Observations By:	KC, Lead Local Flood Authority
------------------	-----------------------------------

**Consultation Response from KC,
Lead Local Flood Authority**

2025/91538 Jewson Property And Services Division, St Andrew's Road, Huddersfield, HD1 6PX

**Discharge of details reserved by conditions 6 and 7 (drainage) on previous permission
2025/90320 for erection of extension to existing warehouse; demolition of warehouse entrance
canopy and southern section of existing warehouse; demolition of existing timber storage area
and erection of covered external racking area and associated works**

Client <b>Stark Building Materials Ltd</b>			
Project <b>Jewsons, St Andrews Road Huddersfield</b>			
Drawing title <b>Proposed Drainage Plan</b>			
Drawn	Chkd	Date	Scale
PB		Dec 2024	Varies
Sheet Size	Drawing No.	Revision	
A1	24399-DR-C-0102		T1

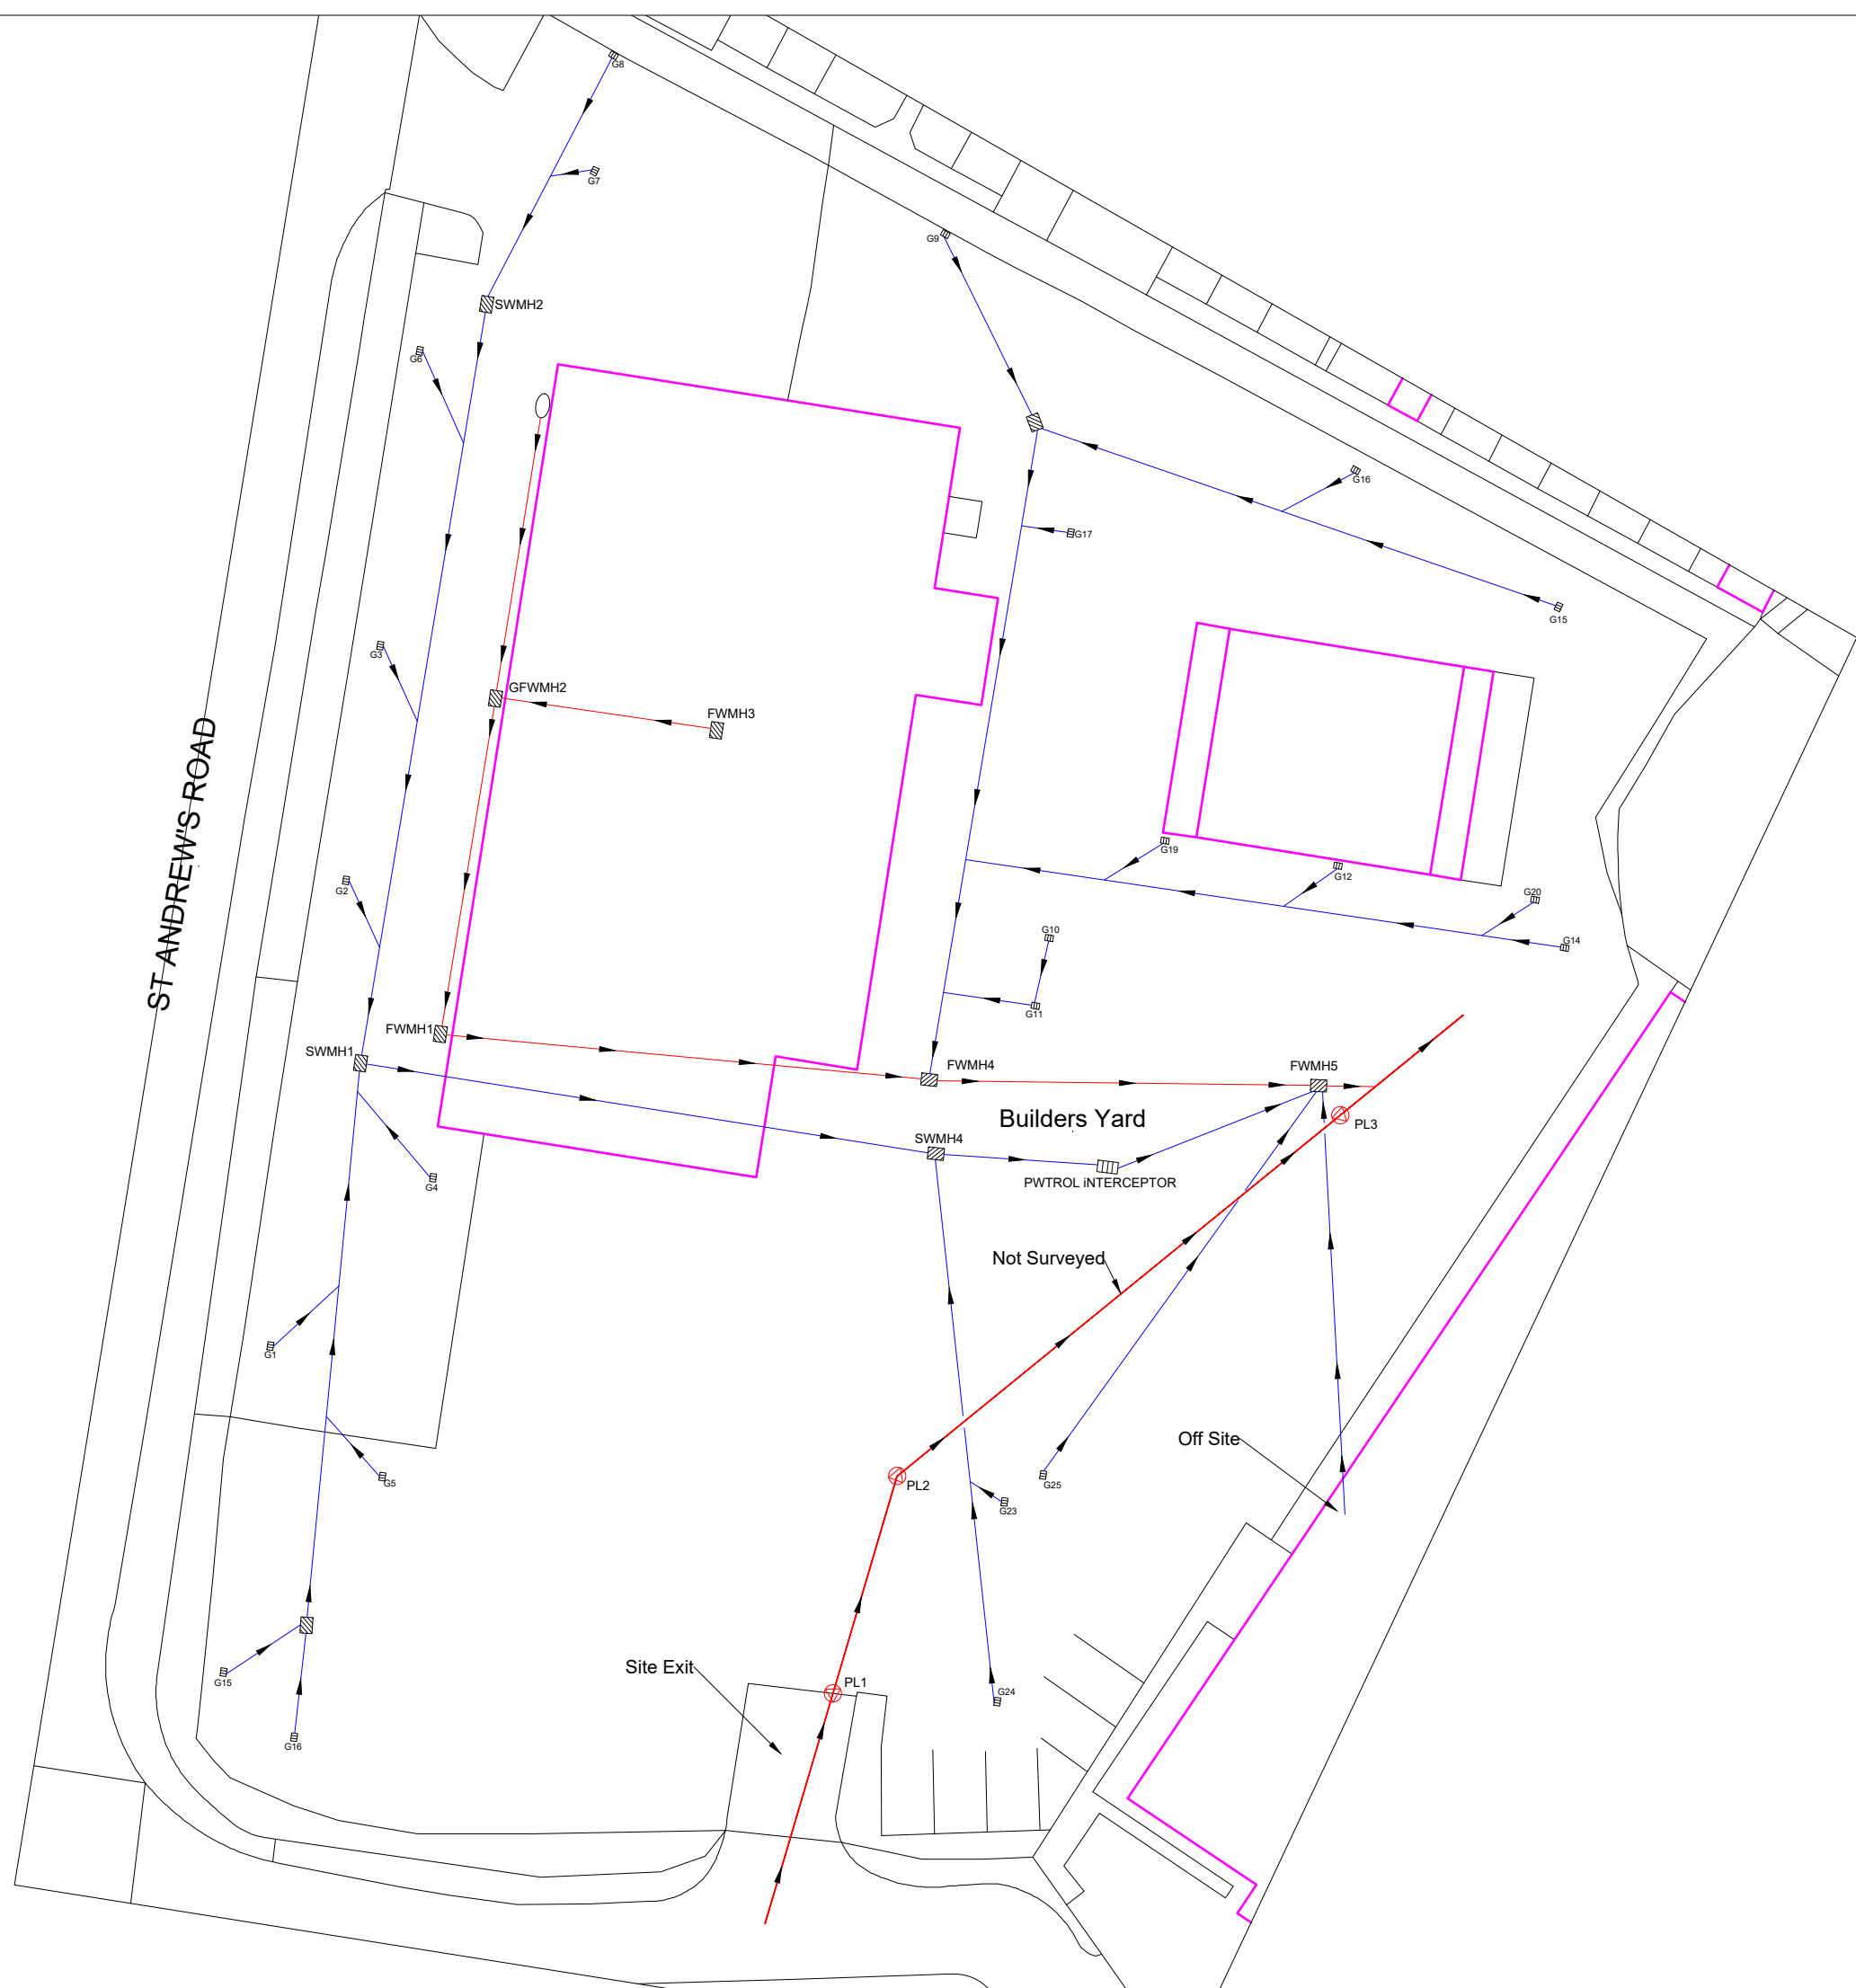
Evidence has been provided that an oil/petrol interceptor is already used on site.

We recommend that this condition be discharged.

Temporary Drainage Strategy

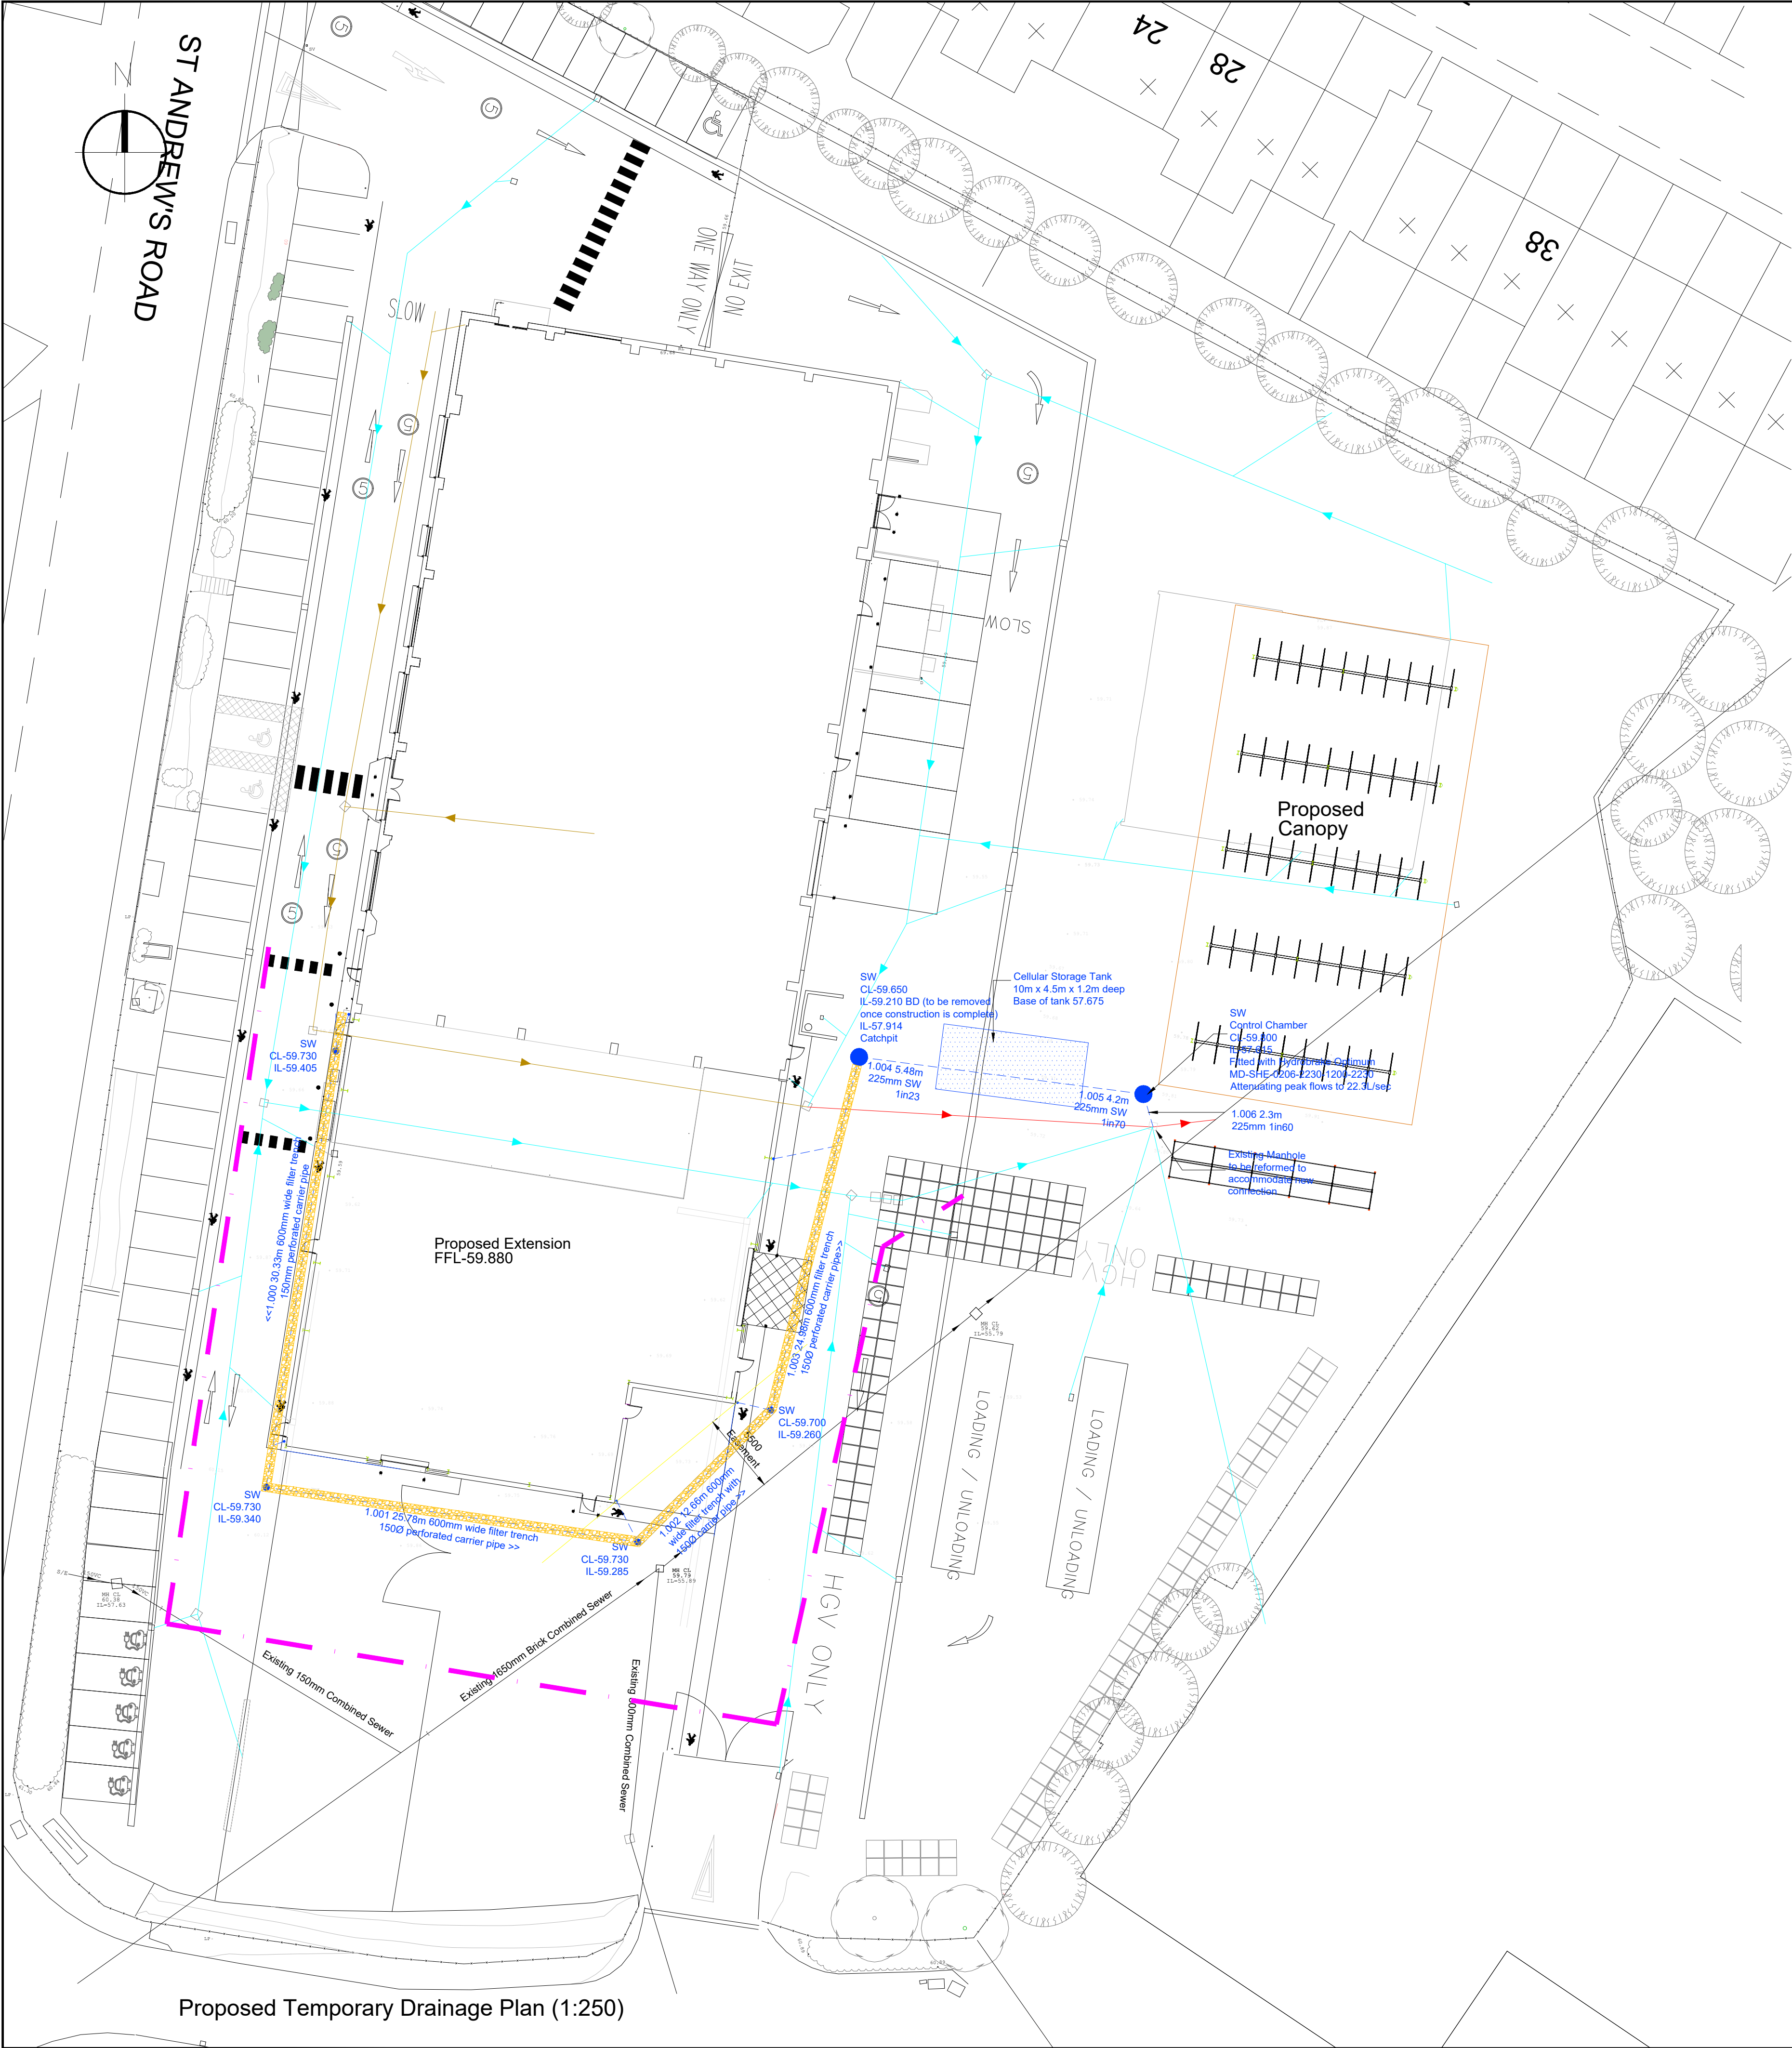
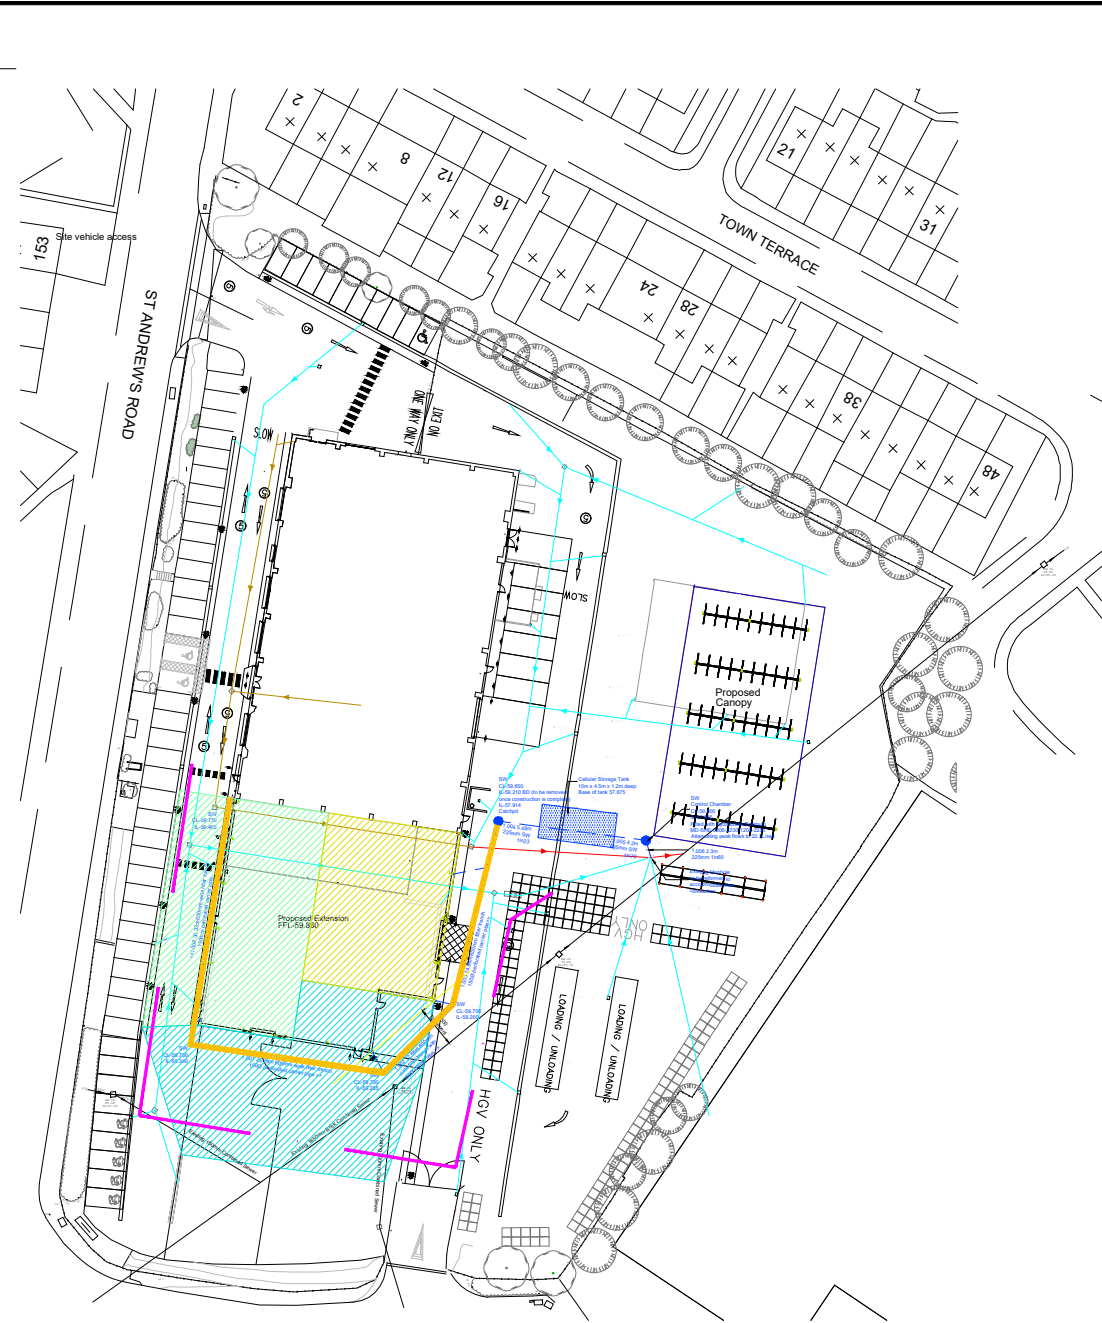
A plan proportionate to the application is still required. In this instance existing drainage need to be protected from debris and silt entering the system. We agree that a wider site wide bund and sump system is not required for such a development.

We do NOT recommend that this condition is discharged at this moment in time.
